From: Biazar, Shahab
Sent: Monday, January 11, 2016 12:15 PM
To: Yolanda Padilla Moyer; Chris Sholtis
Cc: Harmon Rita T. (rharmon@cabq.gov); Abiel X. Carrillo (acarrillo@cabq.gov); Elliott, Stanice (staniceelliott@cabq.gov)
Subject: RE: DMP for Pulte @ Mirehaven Phase 2, N-2-D of the Watershed Subdivision (H09/D017E)

After reviewing the revised plans for the DMP for Pulte @ Mirehaven Phase 2, N-2-D of the Watershed Subdivision (H09/D017E) I have the following comments:

PULTE @ MIREHAVEN PHASE 2
OVERALL GRADING PLAN

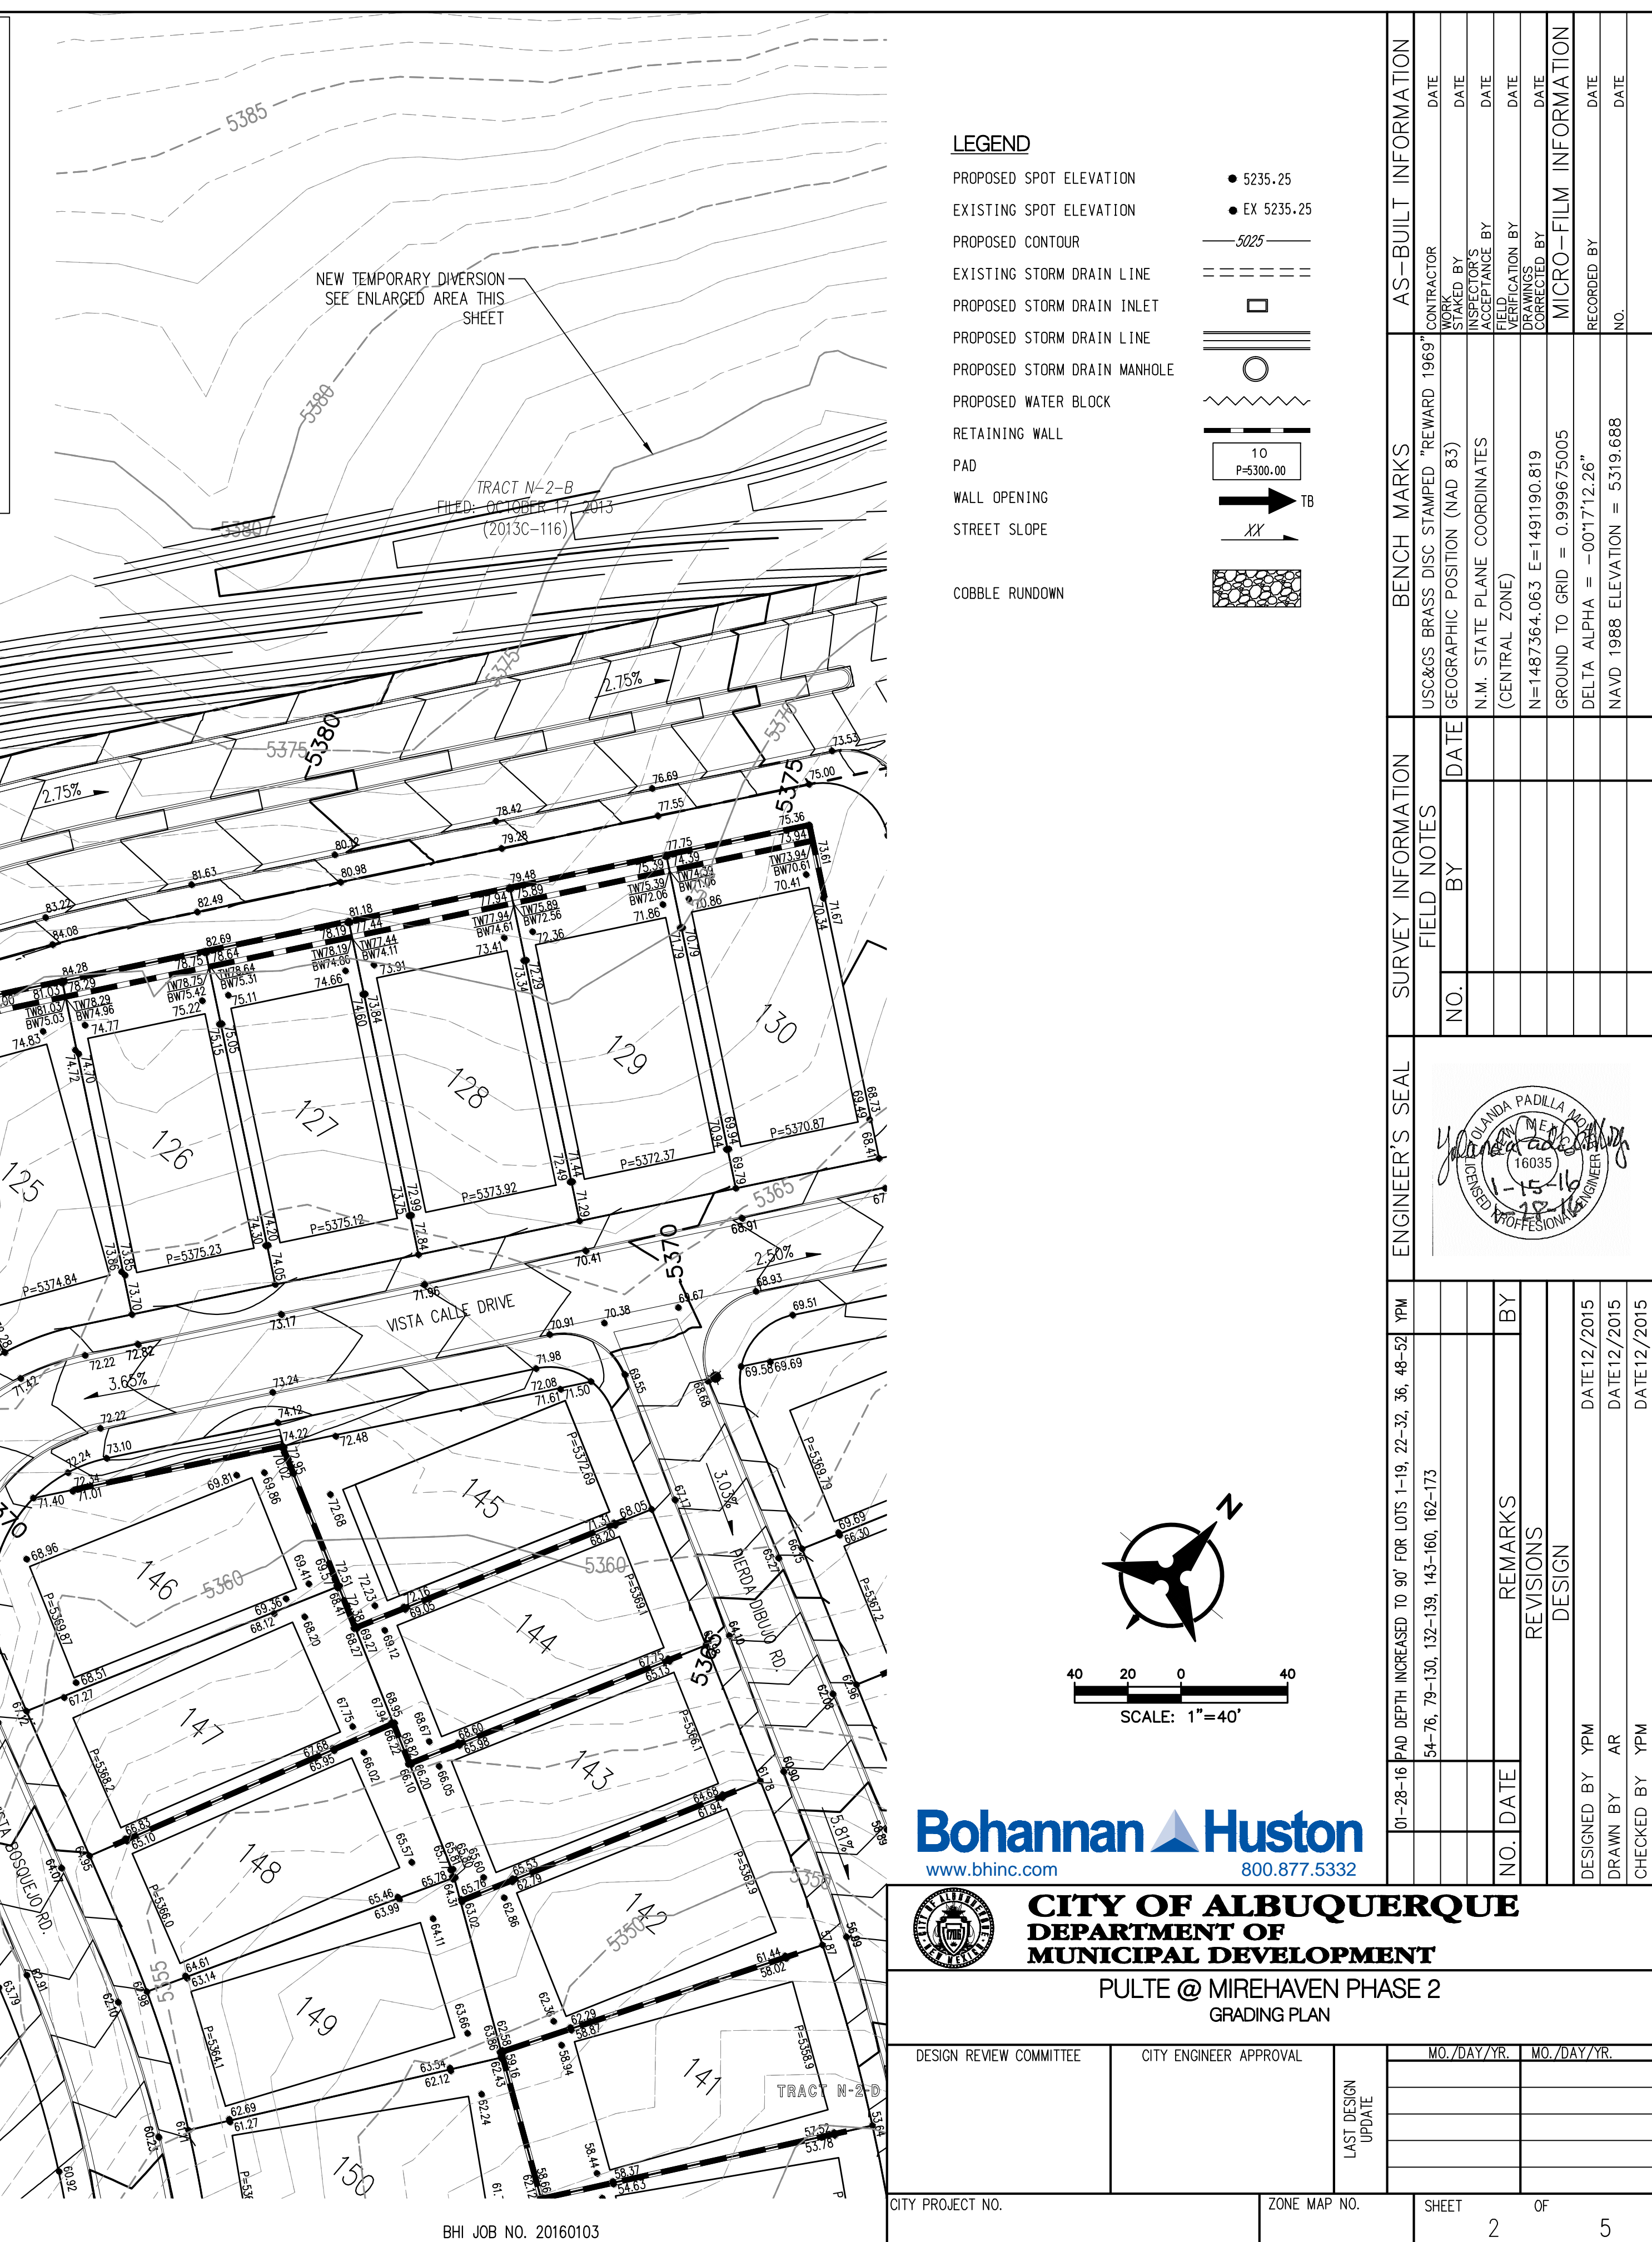
- DMP shows that Vista Calle Drive is to drain to Vista Fiesta. Therefore, water block must be placed at the north end of Piedra Dibujo Road and Vista Dibujo Road to keep the runoff within Vista Calle Drive.

NOTE: ALL INLETS SINGLE GRATE TYPE 'A' OR 'C', EXCEPT INLET 4 IS A SINGLE GRATE TYPE 'D'

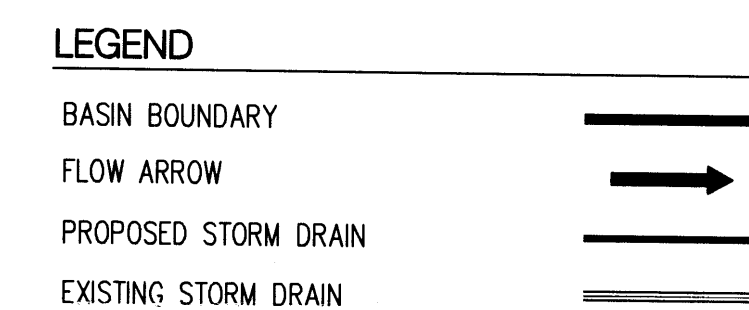
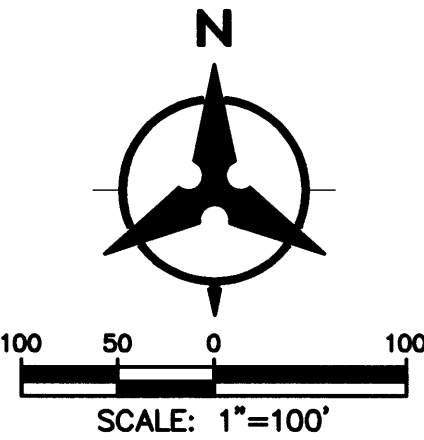
- Update storm drain map to reflect all the latest changes. Include the type of inlets (A or C) for each inlet. Provide all pipe sizes and capacity.
- Lots 6-20 drain to the back of the lots, to a swale and then to Abo Canyon Drive. The swale appear to go through an existing retaining wall. How does runoff get to Abo Canyon Drive? Does it drain over the wall and then over the sidewalk? It might be better to drain the runoff to the north to the pond and then to Abo Canyon Drive. Will there be sidewalk culvert?
- Section A-A shows a dimension of 7'-12' for the upper wall. Will the 7' be adequate for the swale or should it be 8' minimum? Is the 1" rock adequate size for the amount of runoff? Will there be a need for drop structures/erosion protection?
